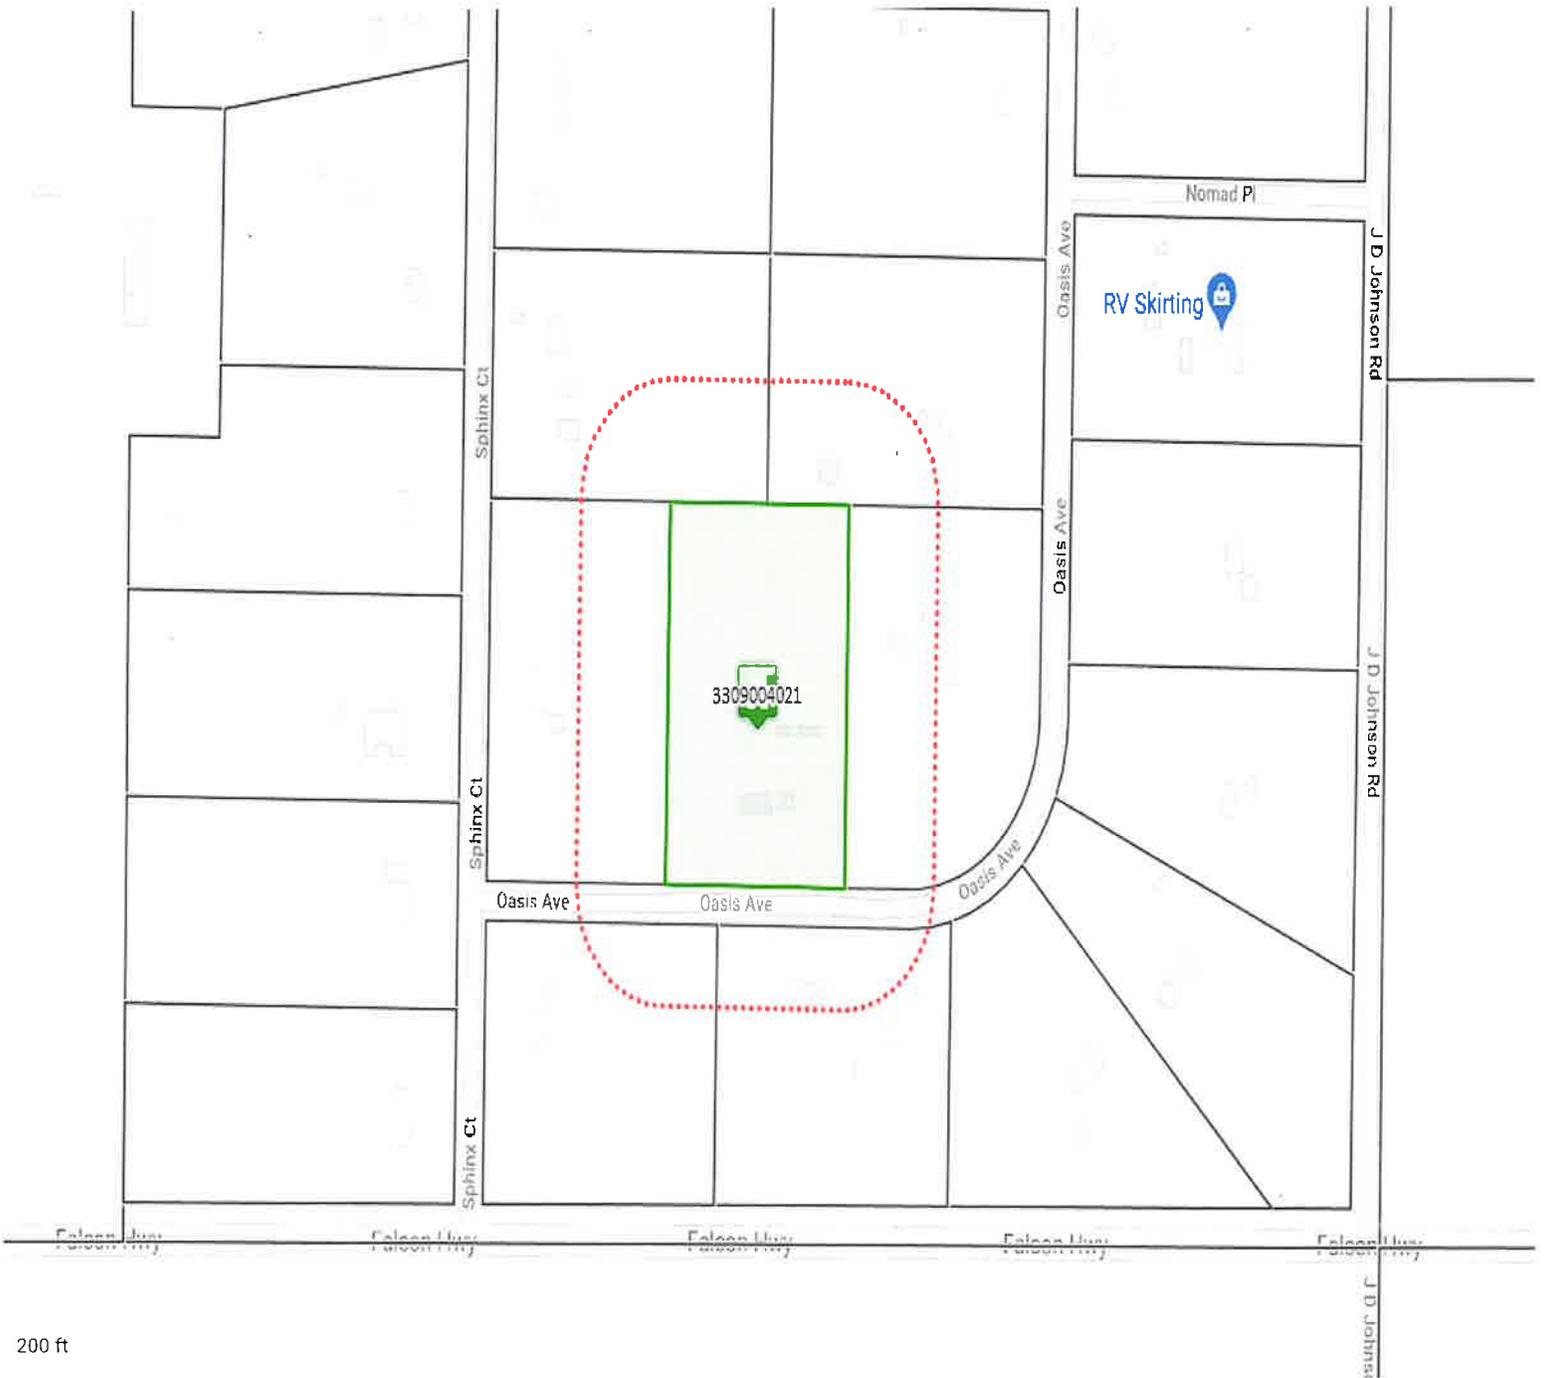
Show 10 Foot easements around all property lines

Expand the view of the site plan. Put the property lines and adjacent property owners on the plan.

Where do the animals live?
